NC DEPARTMENT OF  
**HEALTH AND  
HUMAN SERVICES**

August 20, 2025

RE: 7-Eleven  
1360 NC 24-87  
Cameron, NC 28326

This letter acknowledges review of plans for the remodel of the above referenced establishment. The original plans dated 06/06/25, revised application, and specifications, including email correspondence are conditionally approved with the following comments:

FINISH PLAN

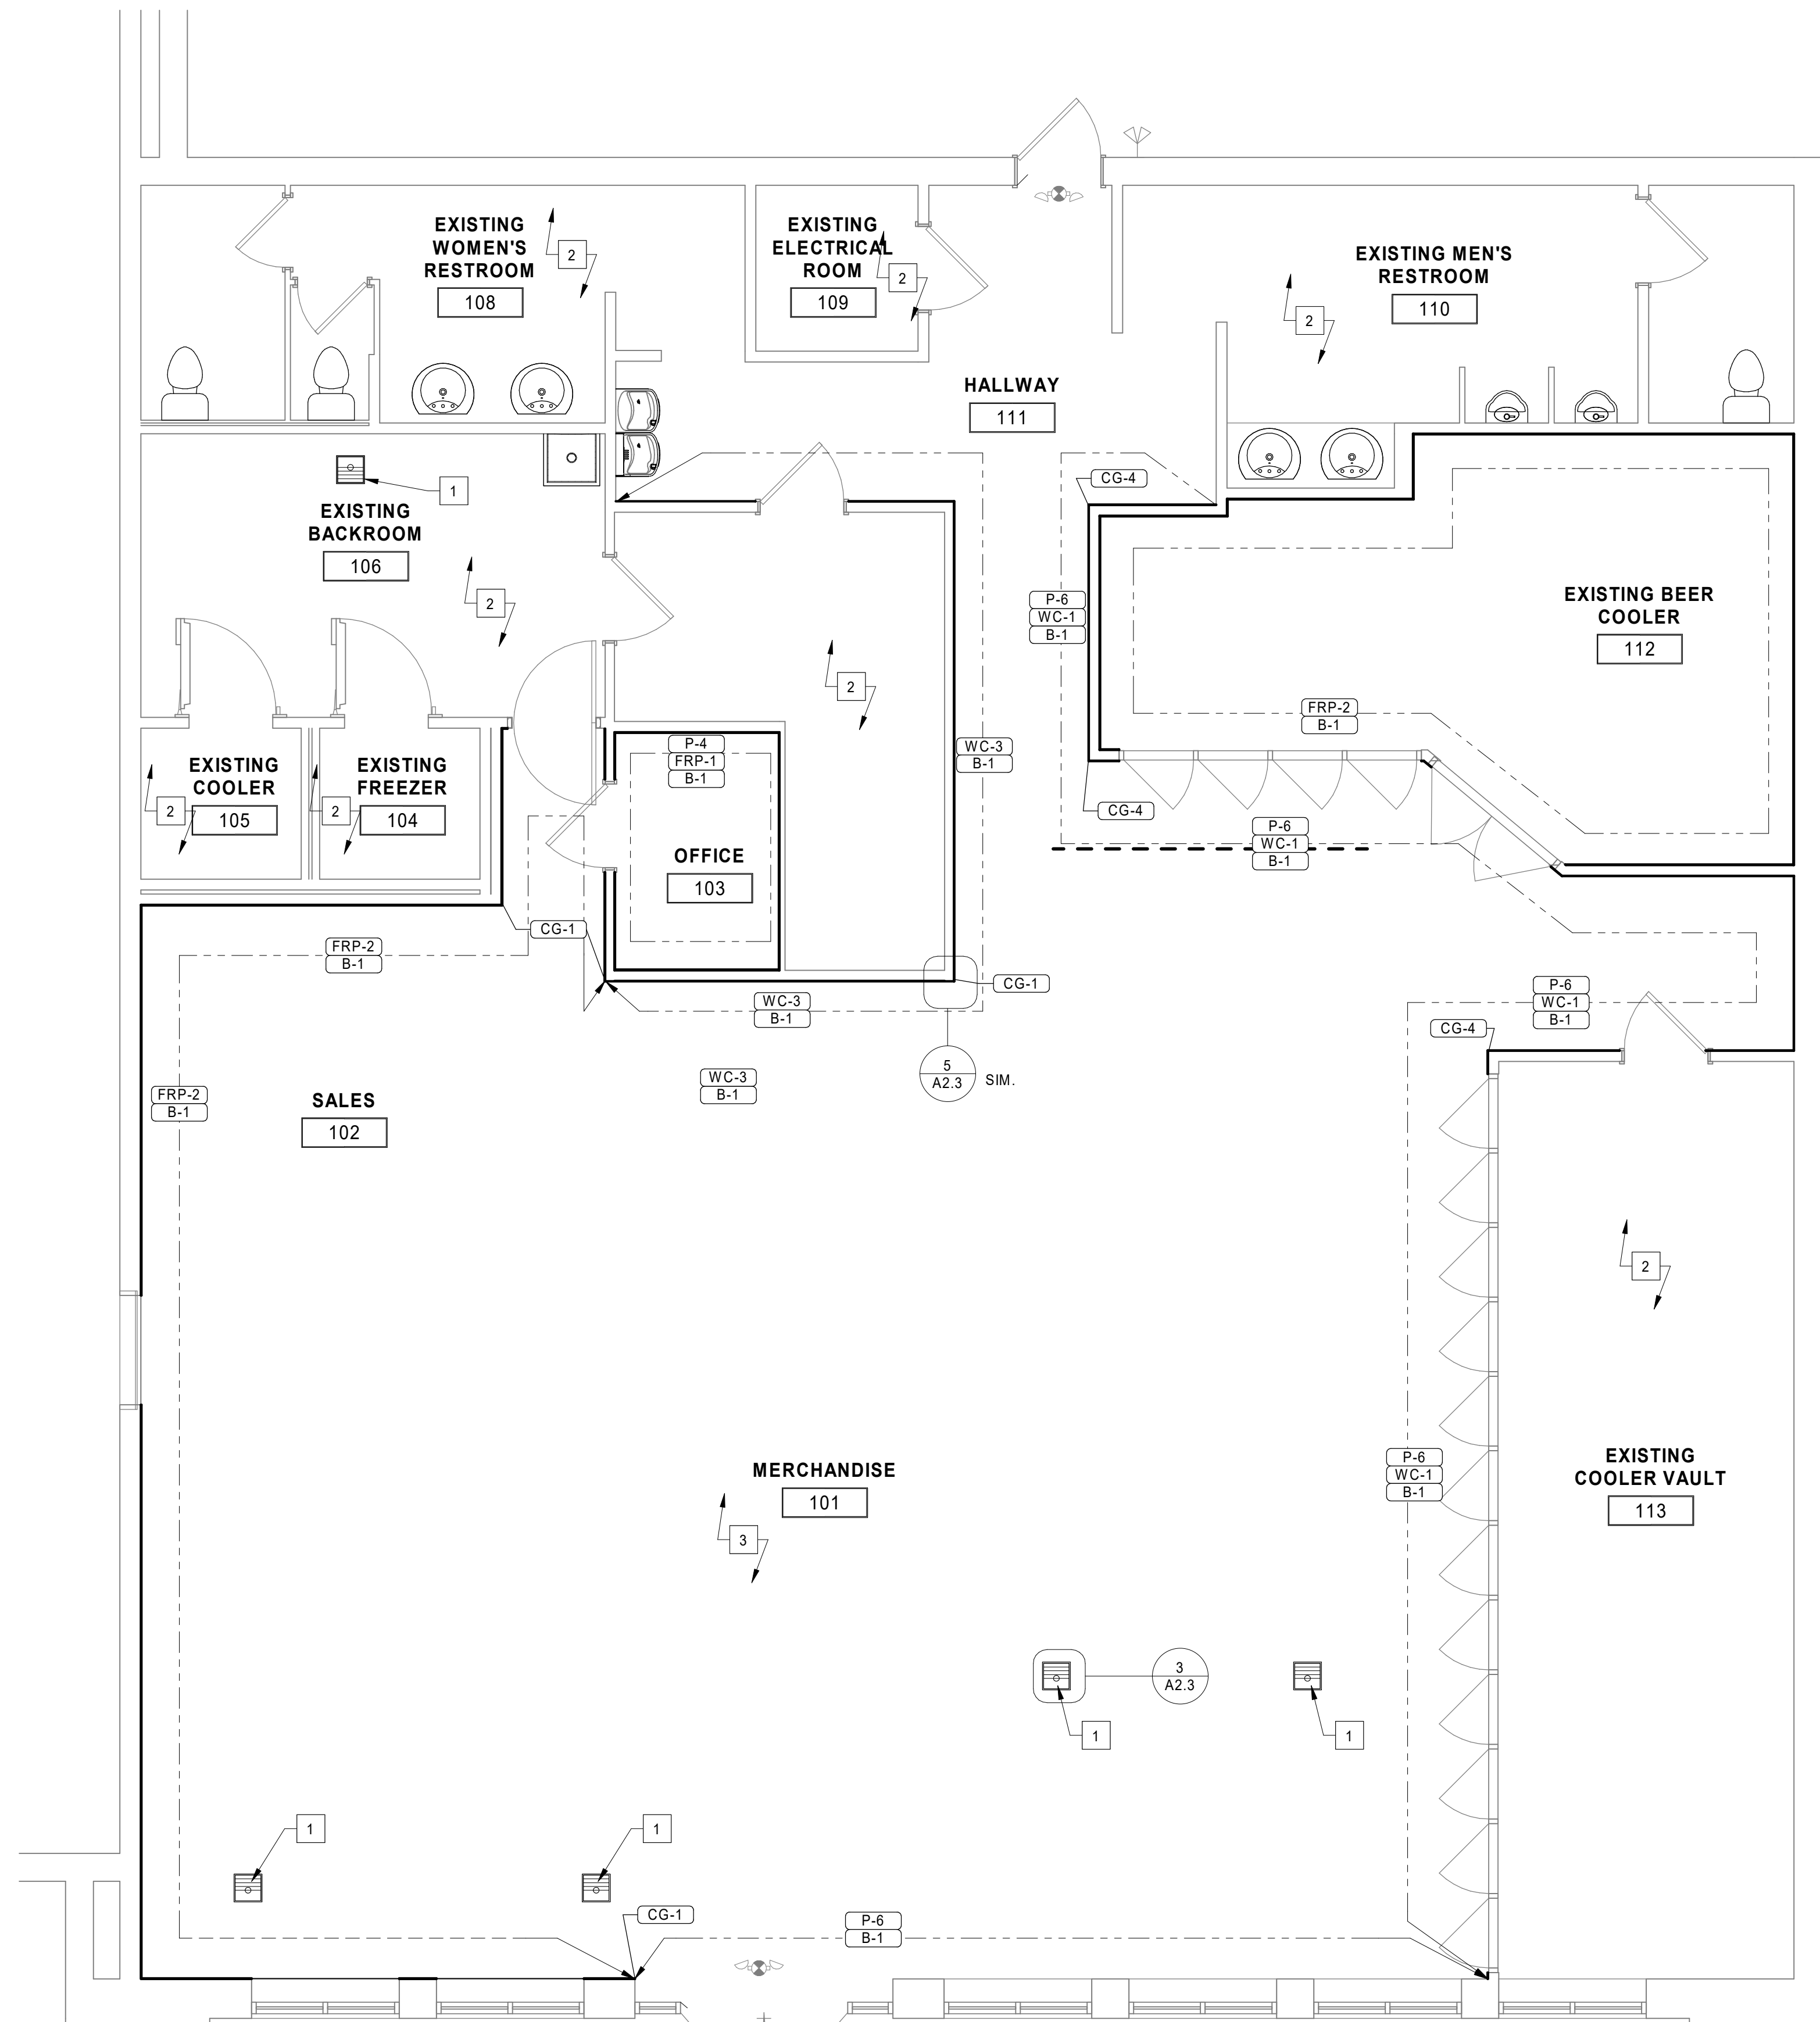
3. The finishes as specified on sheet A6.1; Materials Schedules, and on the application must comply with Subparts 6-101 and 6-201 of the Food Code. New finishes must be smooth, durable, and easily cleanable for areas where food establishment operations occur. In addition, the wall and floor junctures in all food service areas, walk-in coolers/freezers and in the toilet room areas must be coved.

DRAIN PIPING PLAN

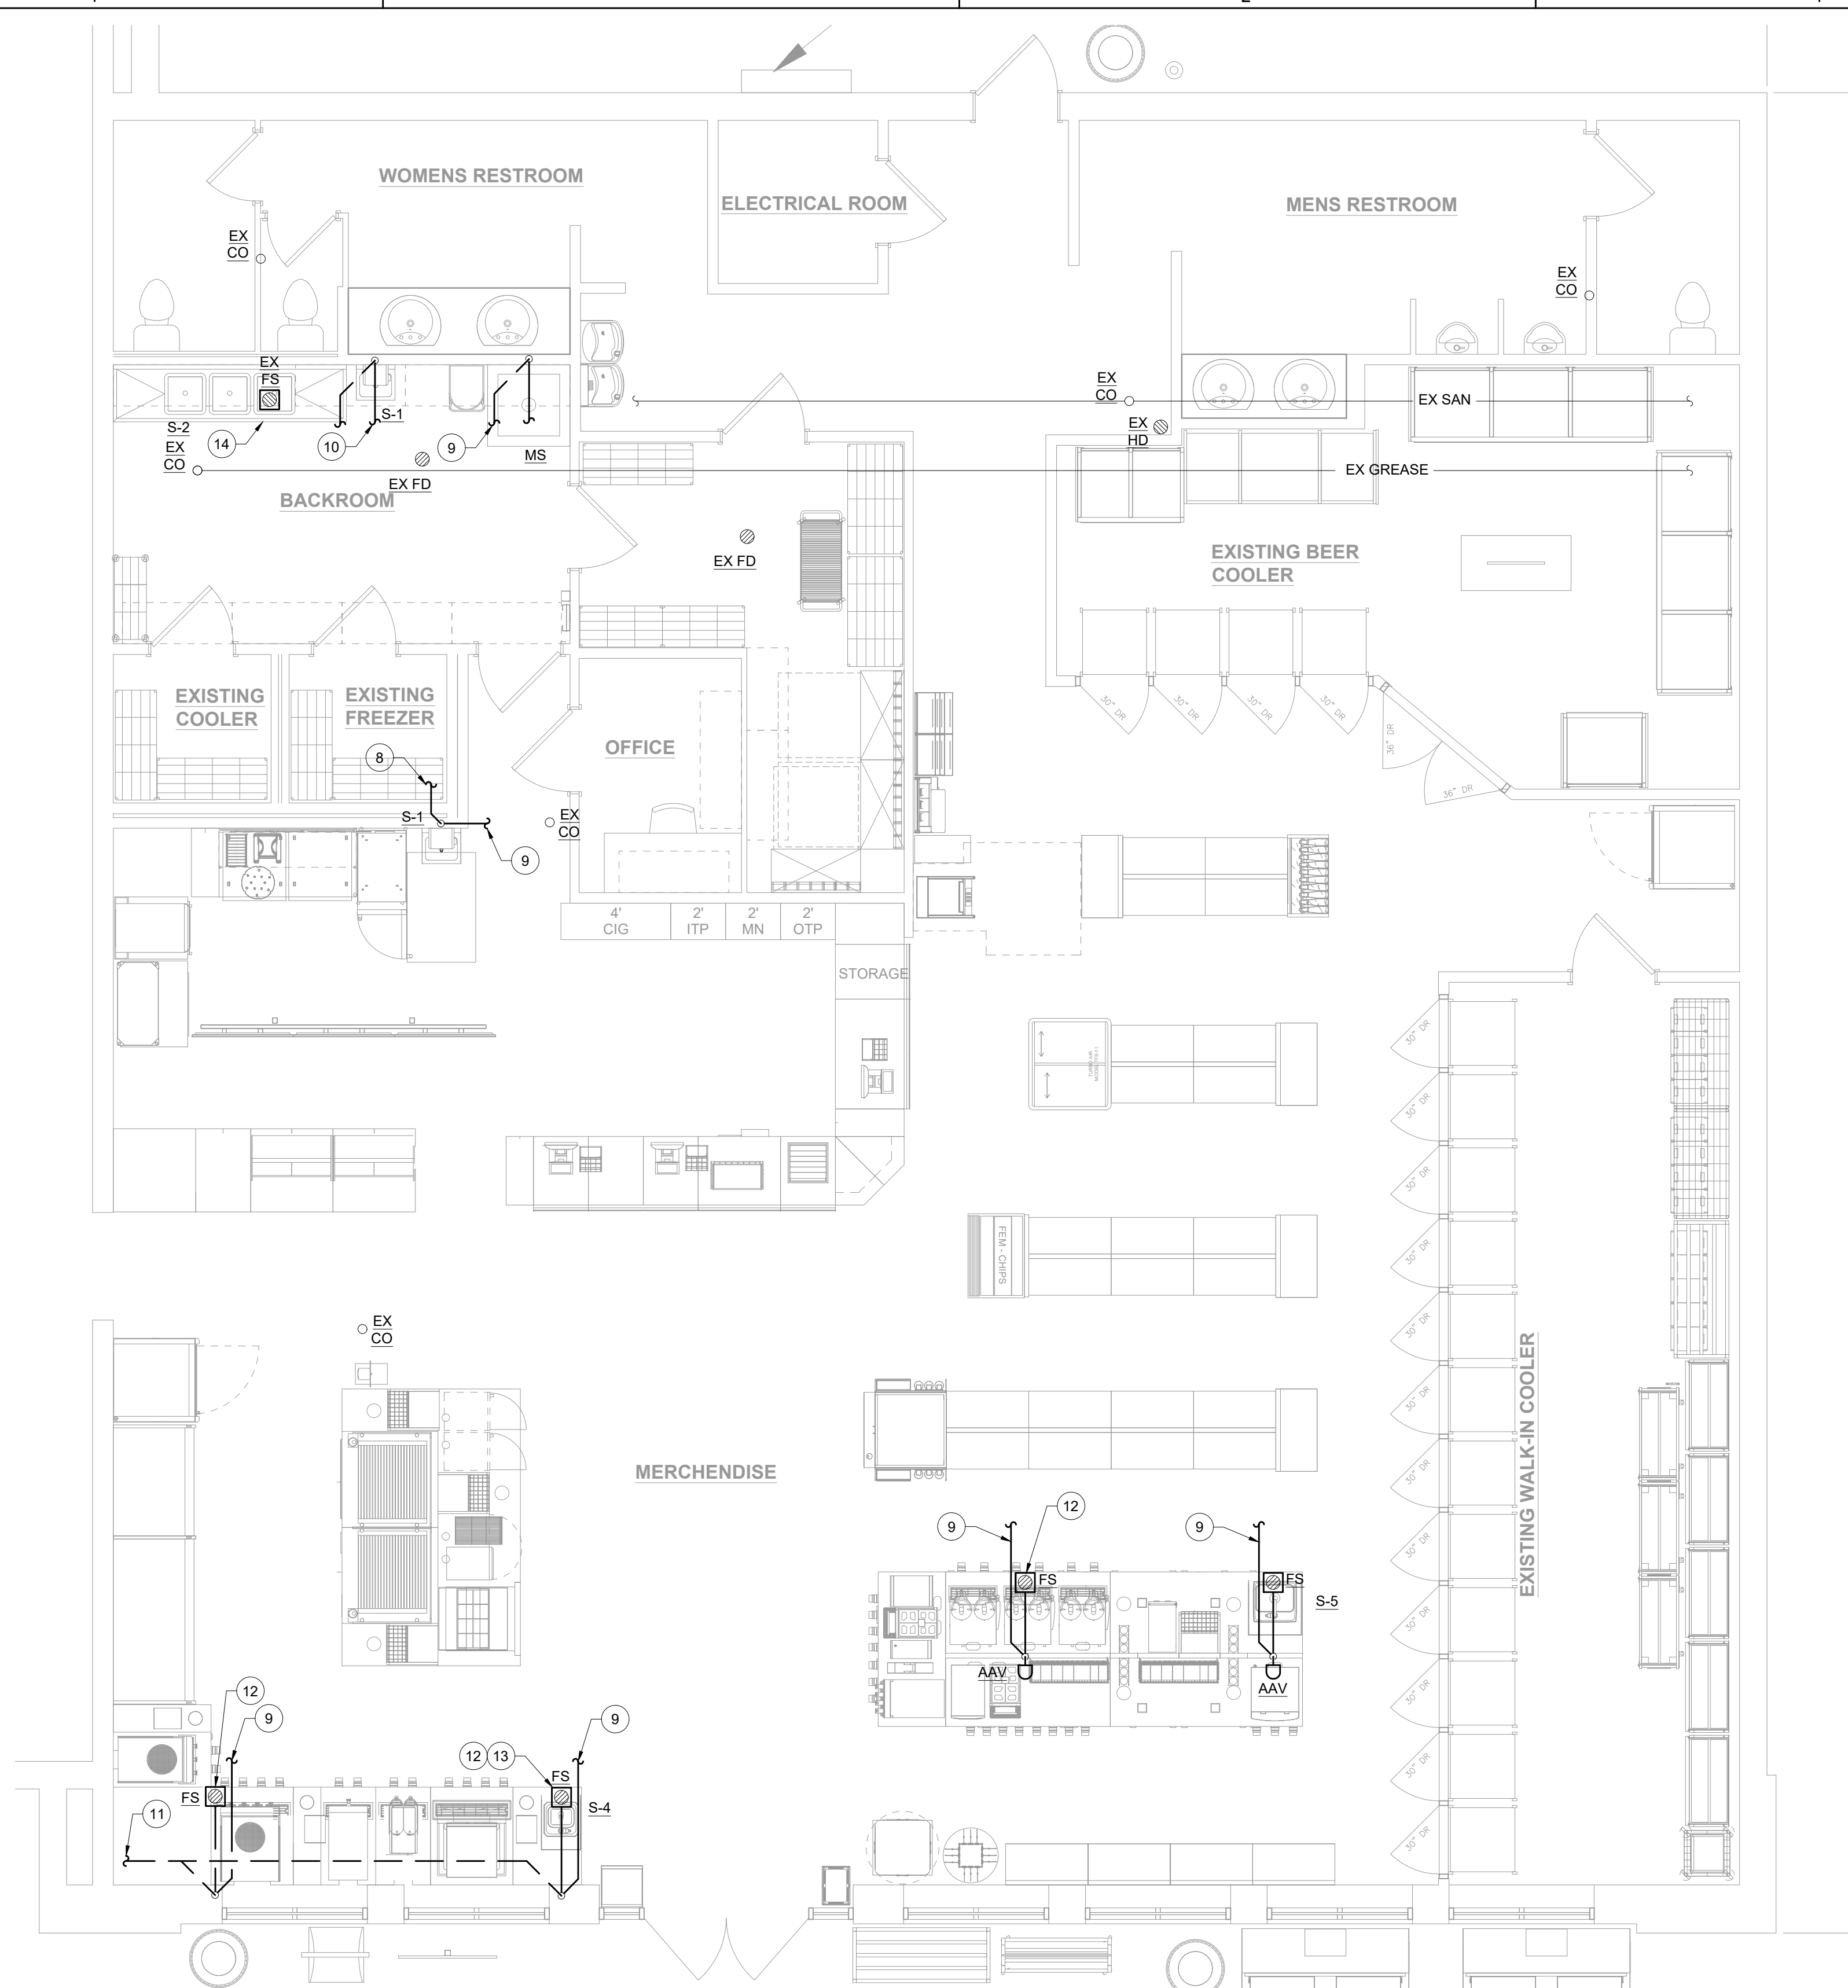
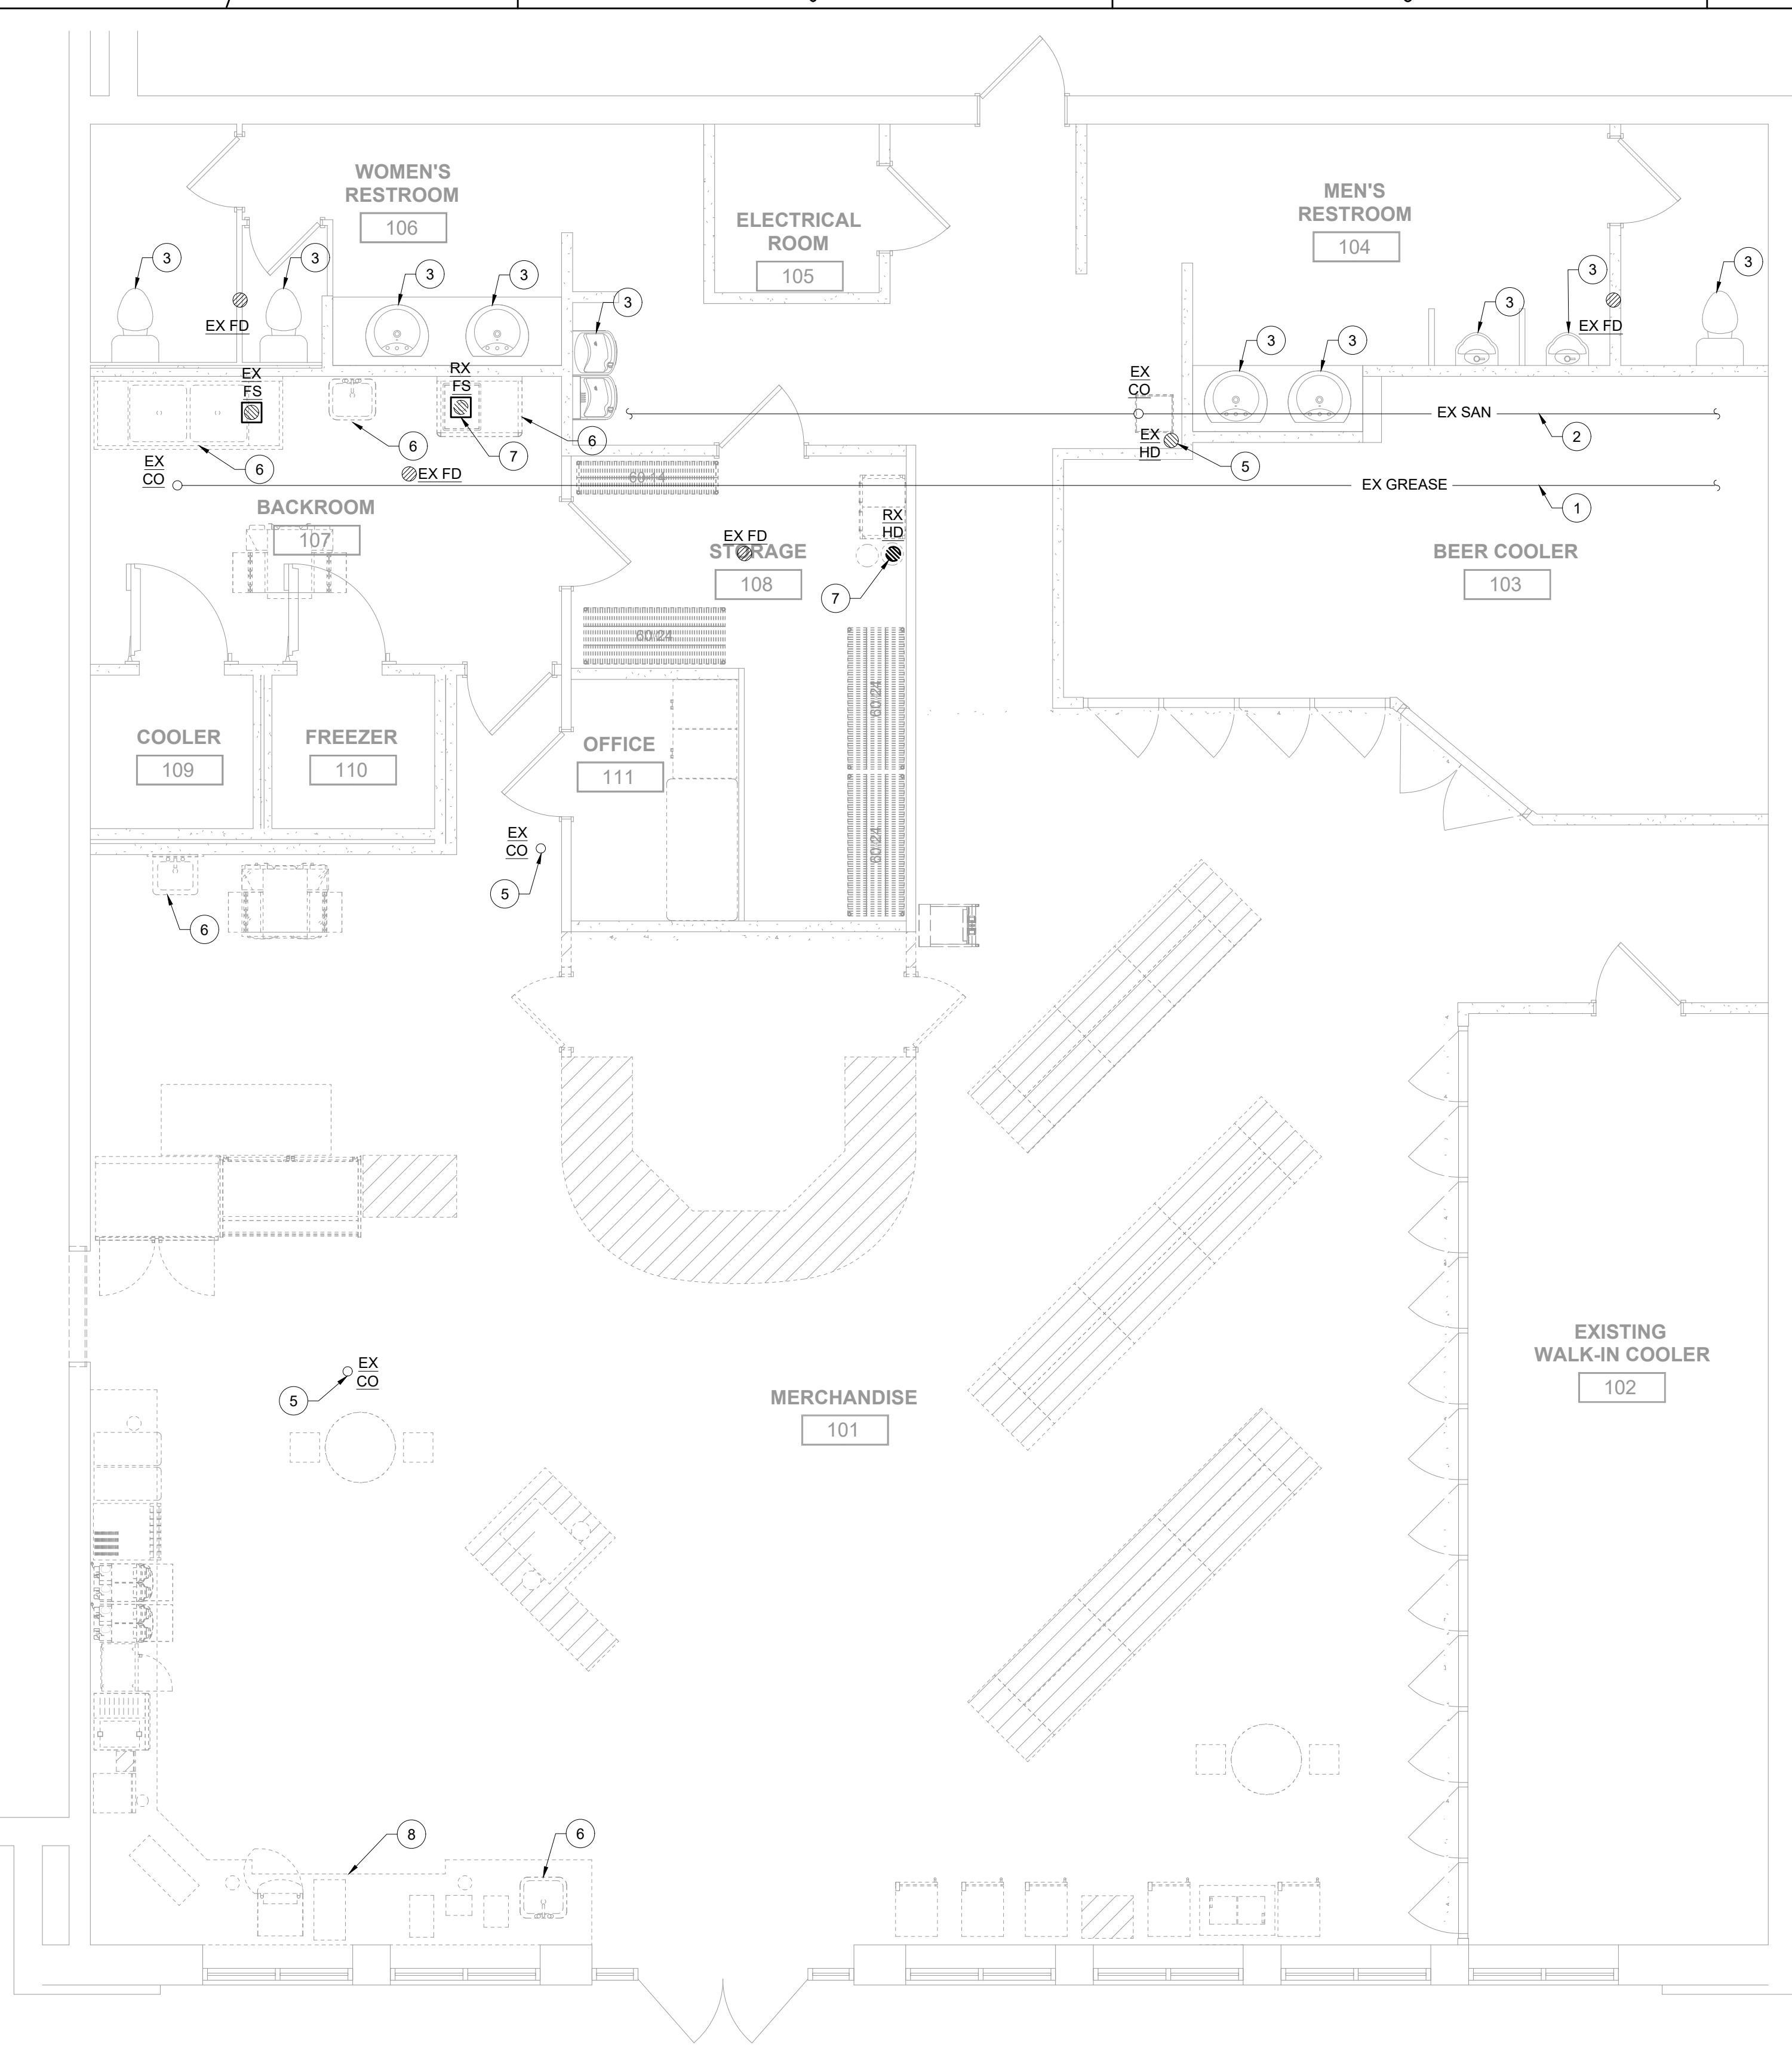
4. Plumbing must comply with all applicable plumbing regulations. These shall comply with Parts 5-1 and 5-2 and Parts 6-3, 6-4, and 6-5 of the Food Code. The Drain Piping Plan on sheet P1.0; Domestic Water Piping Plan on sheet P1.1, and P2.0; Plumbing Details and Schedules plan sheet are conditionally approved with the (2) 199MBH tankless water heaters as noted on sheet P2.0, and on the revised application. It is understood with the acceptance of engineered sealed drawings, if the design of

the hot water heating system does not meet the required hot water demand during peak periods; the hot water heating system will be modified or replaced to meet requirements.
